Subject: BE/16/20/PL

BE/16/20/PL

*Rear of Rookery Farm, 113 North Bersted Street Bersted PO22 9AG
Demolition of storage buildings & erection of 1 No 3-bed cottage.*

Drawing 3 - Proposed Site Plan

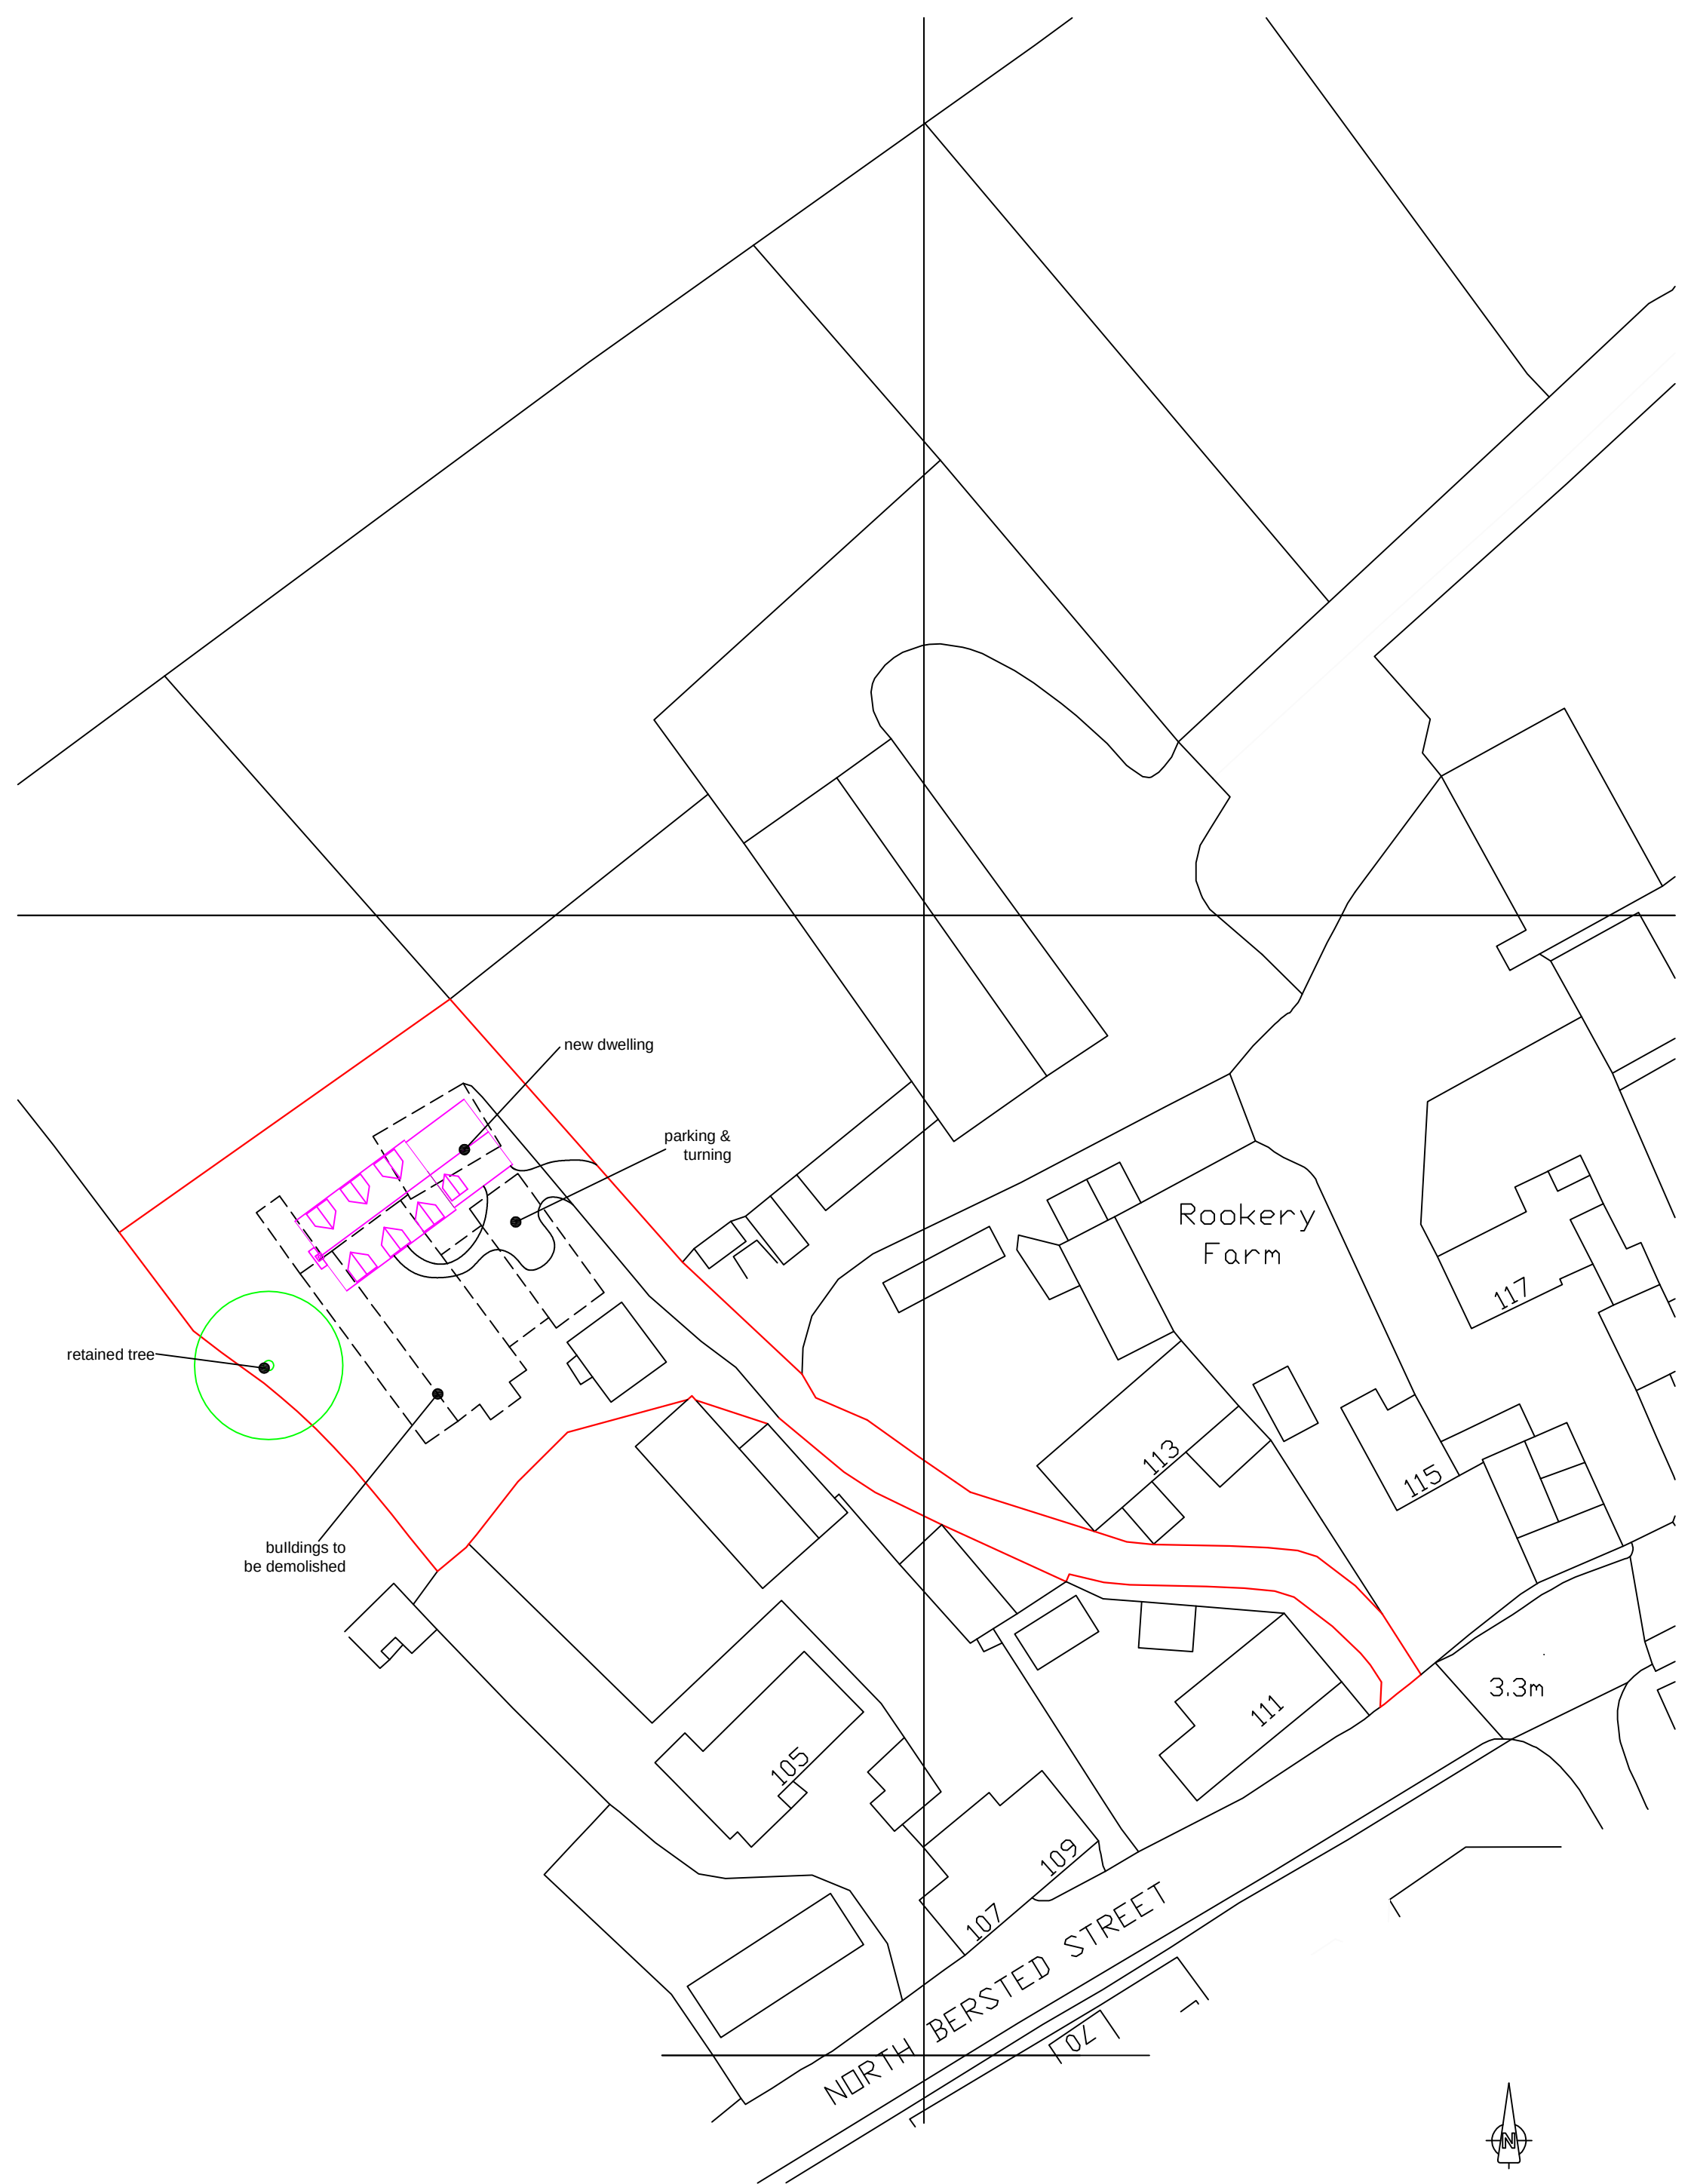
It is considered that whilst a site plan has been provided, it would be helpful to understand how the site will be enclosed. Will standard fencing be used, or is the intention to use a system of hedging and trees which would further aid the transition of the building into the surrounding countryside? Details of this could be provided for by way of condition if you are minded to approve the application.
